Application for a non-material amendment following the grant of BR/135/13/ for the addition of pedestrian gate to entrance of site, move rear garden entrance to Plot 7 to back of carport & hipped roof to carports.

Outline Planning Permission with Some Matters Reserved for the demolition of existing buildings and the construction of 7 No. three bedroom houses, including 3 No. terraced houses and 4 No. semi-detached houses plus ancillary works (re-submission following BR/288/12/).

Old plan/drawing numbers:	02 Rev F - Proposed Site Plan and Landscape Plan 23 Rev A - Units 6 and 7 Plans 24 Rev A - Units 6 and 7 Elevations 27 Rev A - Units 4 and 5 Plans 28 Rev A - Units 4 and 5 Elevations
New plan/drawing numbers:	02 Rev G - Proposed Site Plan and Landscape Plan 23 Rev B - Units 6 and 7 Plans 24 Rev B - Units 6 and 7 Elevations 27 Rev B - Units 4 and 5 Plans 28 Rev B - Units 4 and 5 Elevations

Notes:		
KEY Previously Approved		
CLIENT	Willowcroft Homes	DATE
		06.10.16
PROJECT	Land to Rear of No 6, Ockley Rd, Bognor Regis, PO21 2HW	JOB NO.
		1516132
DRAWING TITLE	Units 4 & 5 Floor & Roof Plans	DRAWING NO.
		27
THIS DRAWING IS COPYRIGHT © Western Design Ltd 2016		REVISION
		B
PLANNING

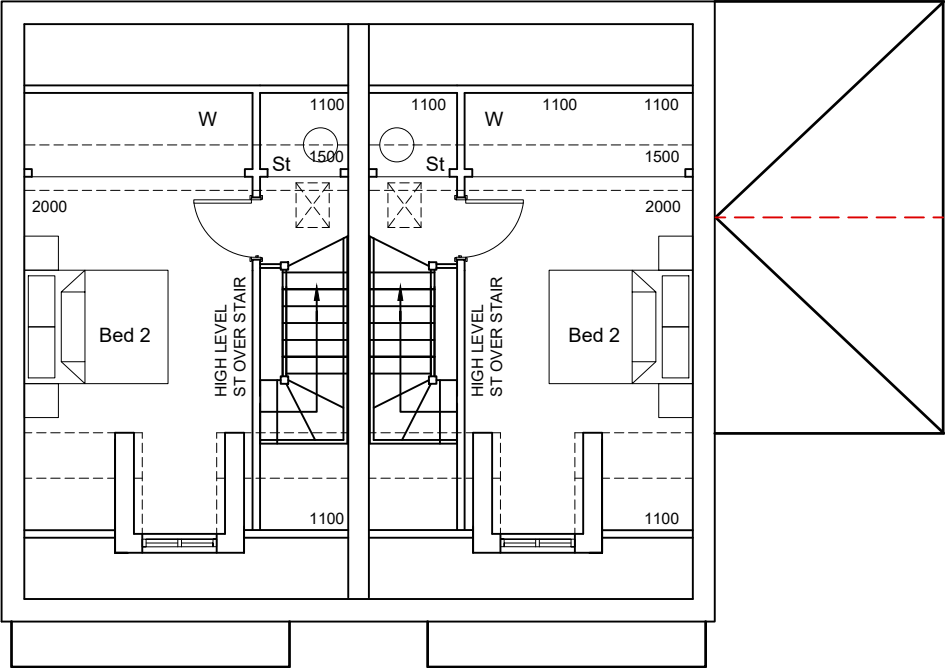
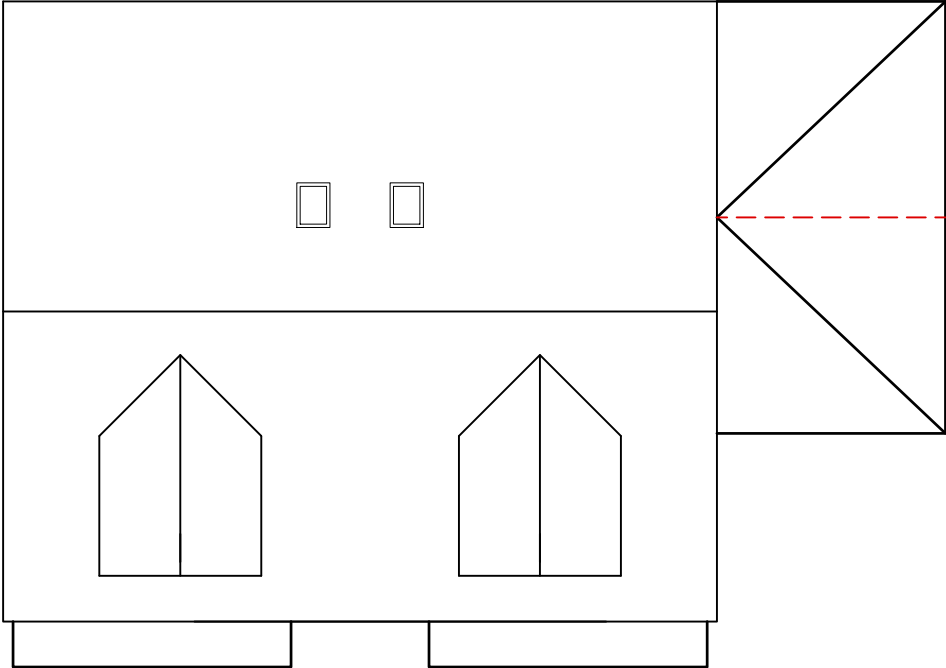
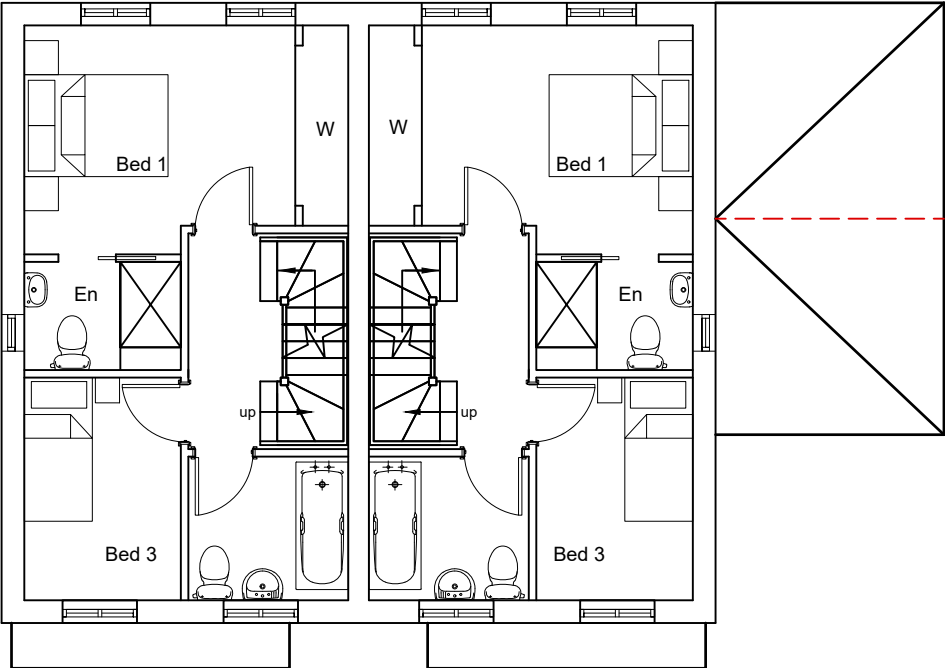
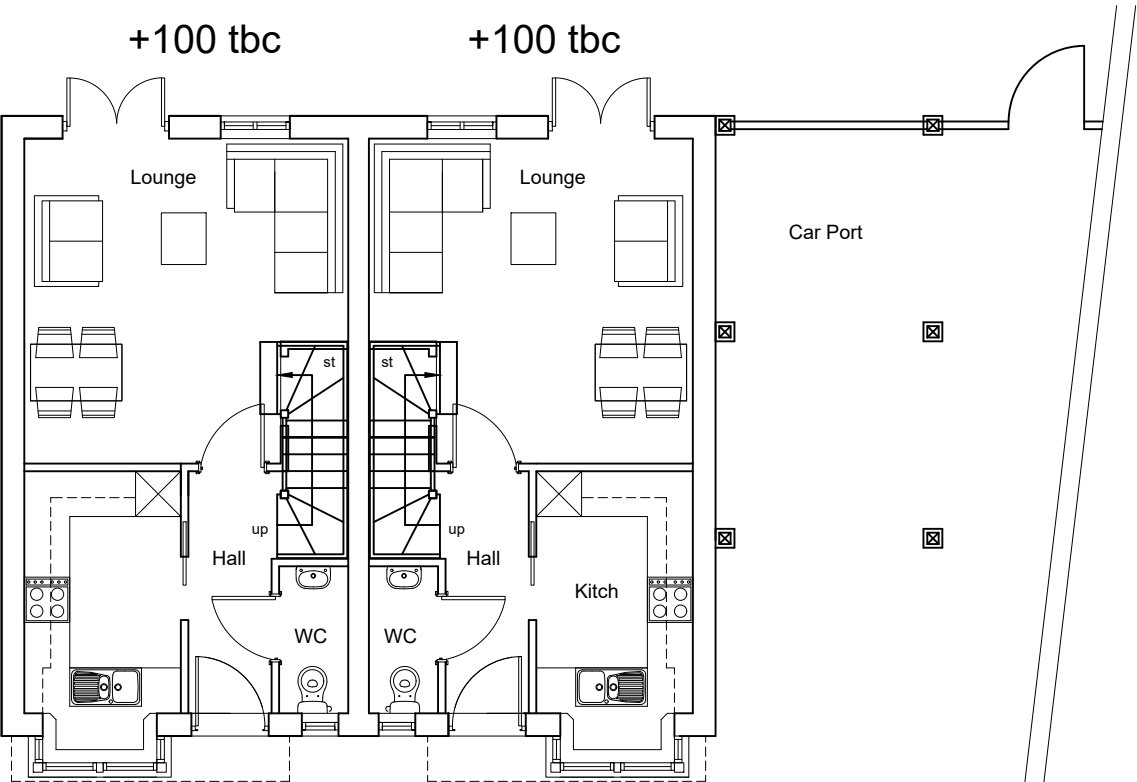
Alterations to the roofs of both car ports (plot 5 and 7) from gable to fully hipped. Landscape changes including extending the garden of Plot 6 by moving the rear entrance of Plot 7 to the North side of the car port for Plot 7. An additional pedestrian gate to the main entrance of the site to allow separate private access to the existing footpath that runs down the East boundary of the site.

Due to both car ports being close to the boundary of the site the hipped roofs will give less impact on the existing neighbouring properties and also allow for the full construction of the car ports to be done from the application site without impeding on neighbouring land.

| Proposed Site Plan<br>& Landscape Plan |

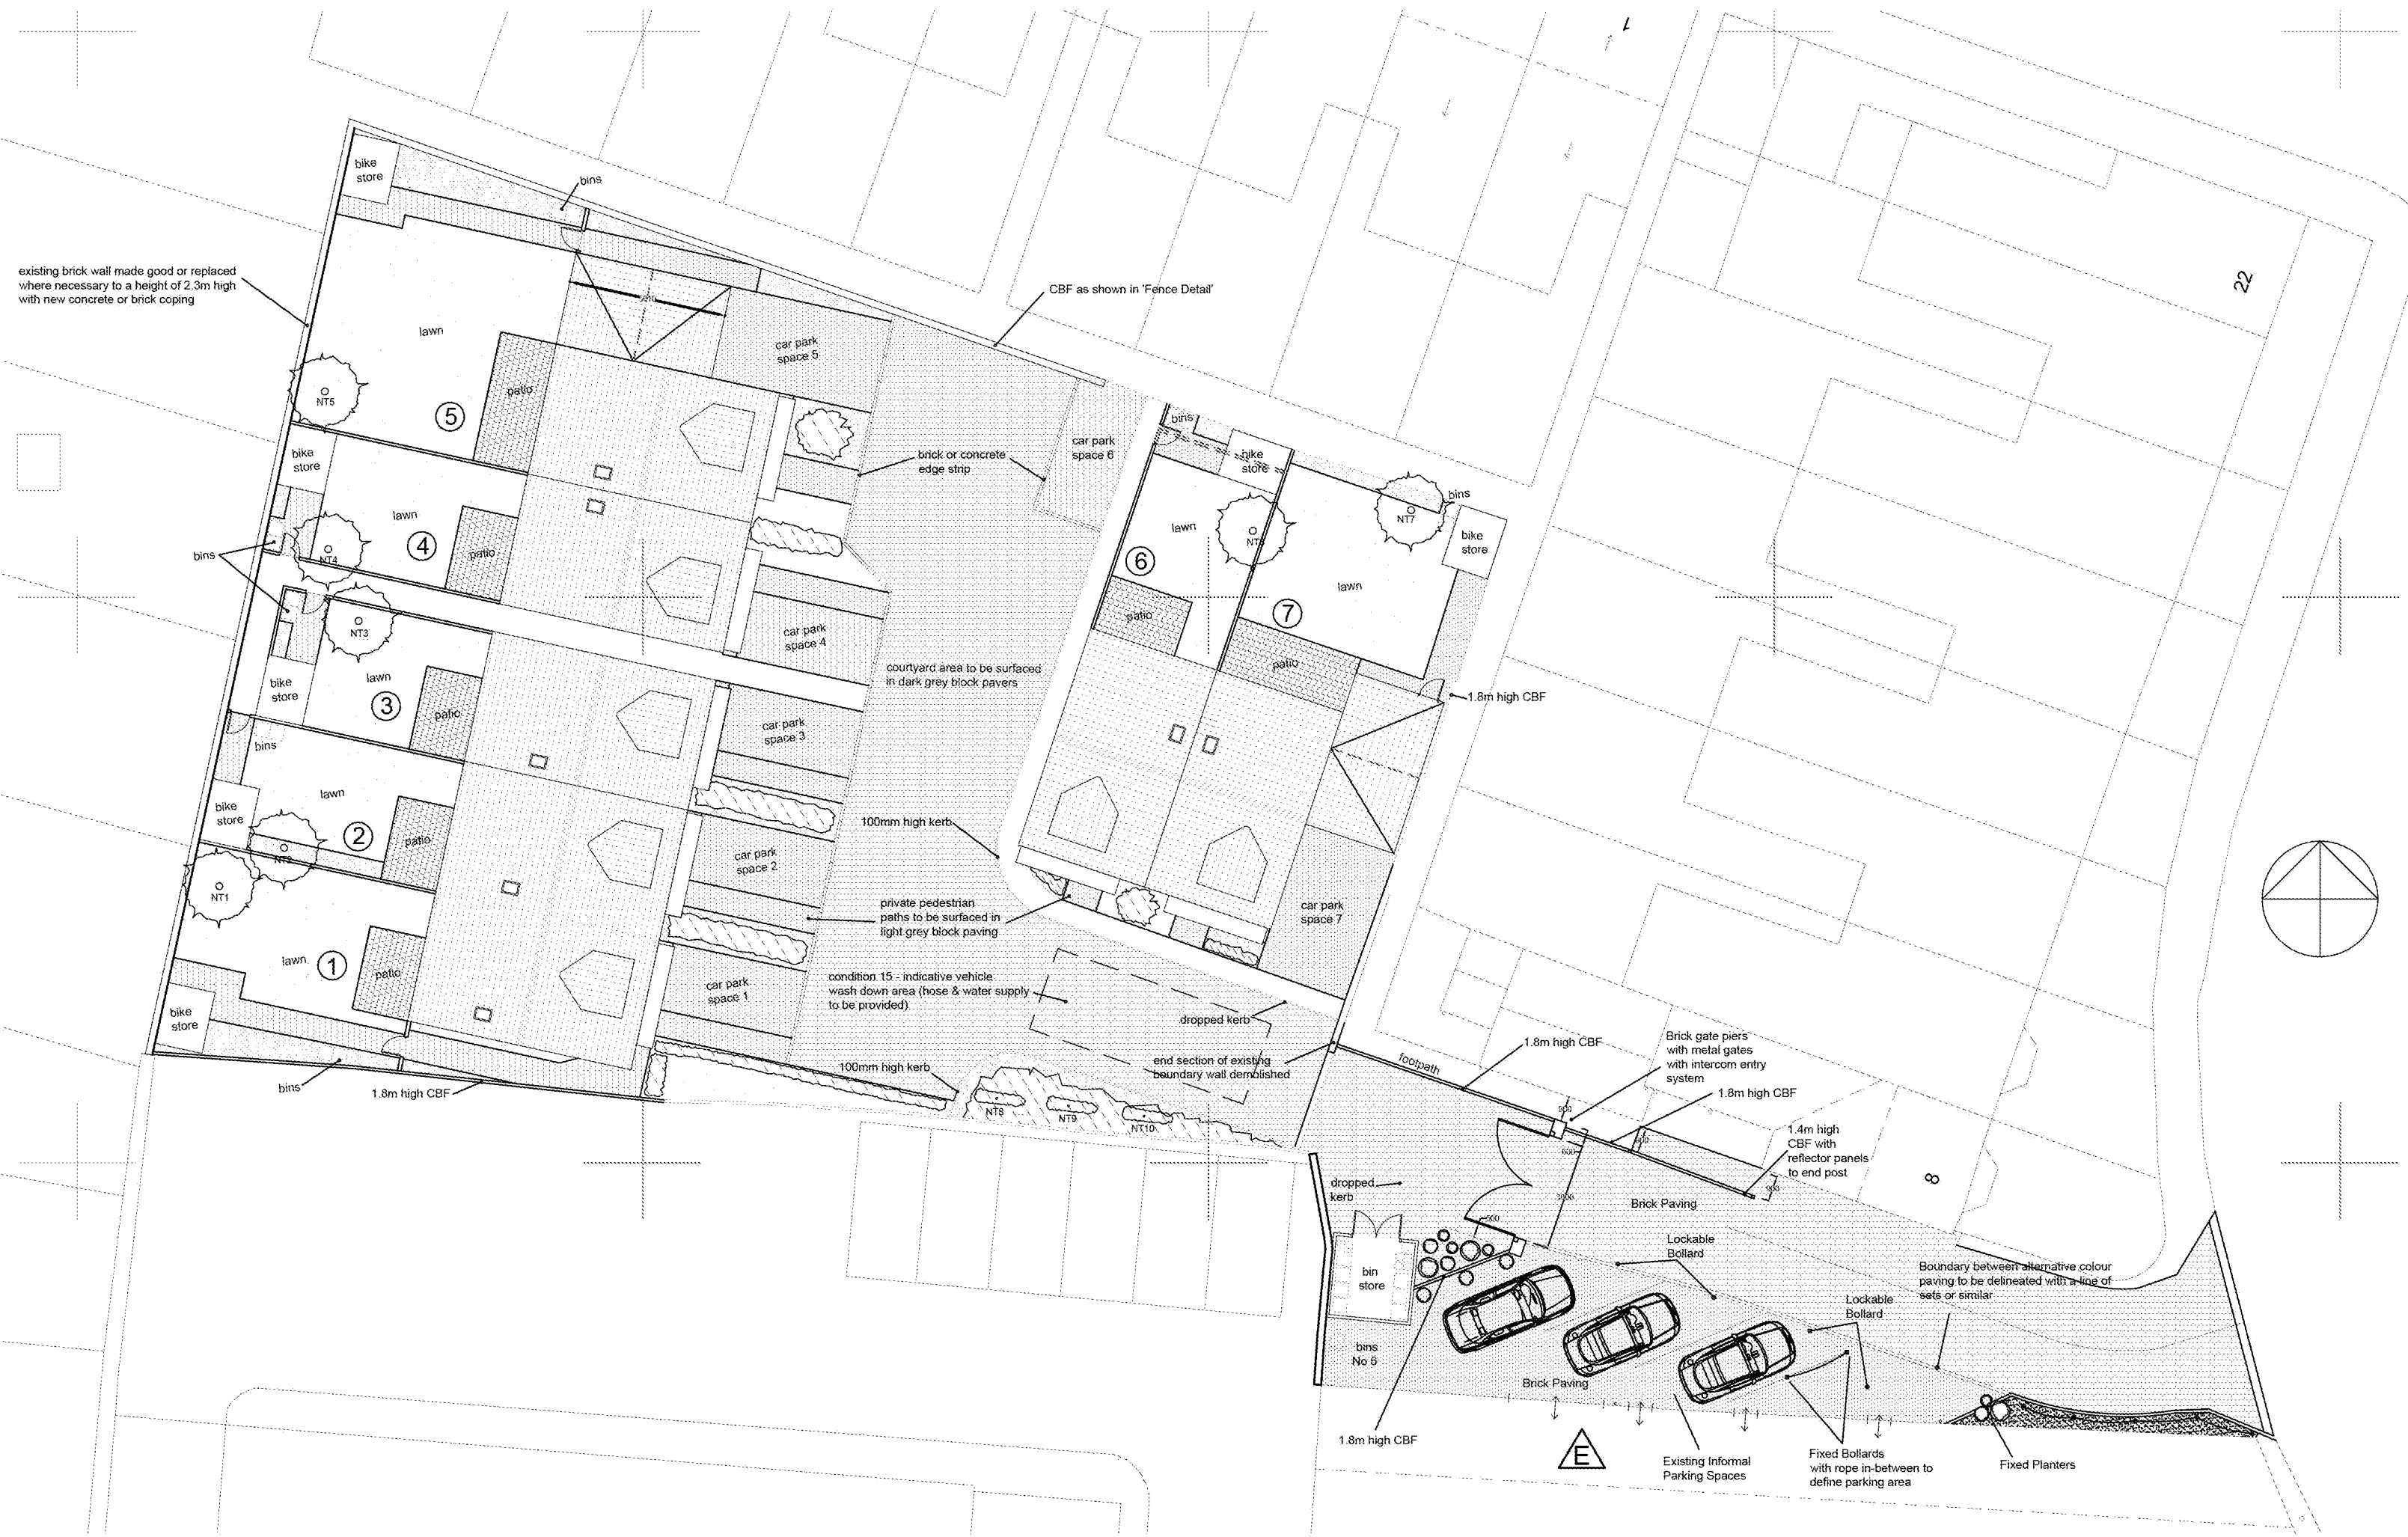
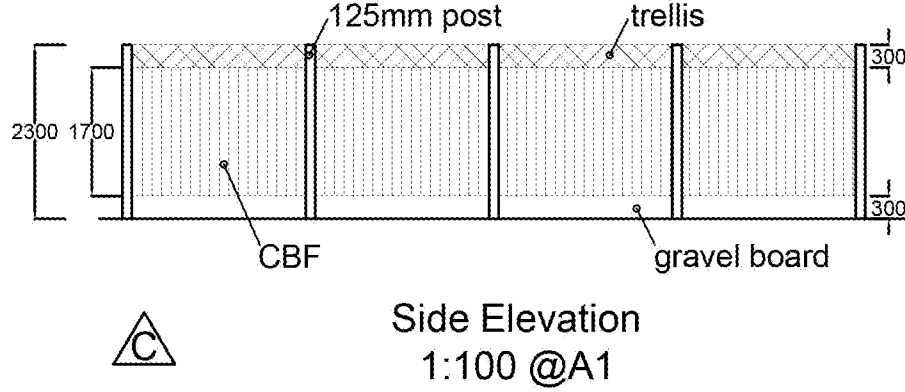
Moving the rear garden entrance to Plot 7 to the back of Plot 7's car port will allow the garden of Plot 6 to be enlarged as it is currently compromised.

The addition of a new pedestrian gate to the entrance of the site will allow the existing neighbours to have a separate, private entrance to their existing rear footpath along the East boundary of the site (this amendment is in response to a complaint from one of the neighbours who use this footpath).
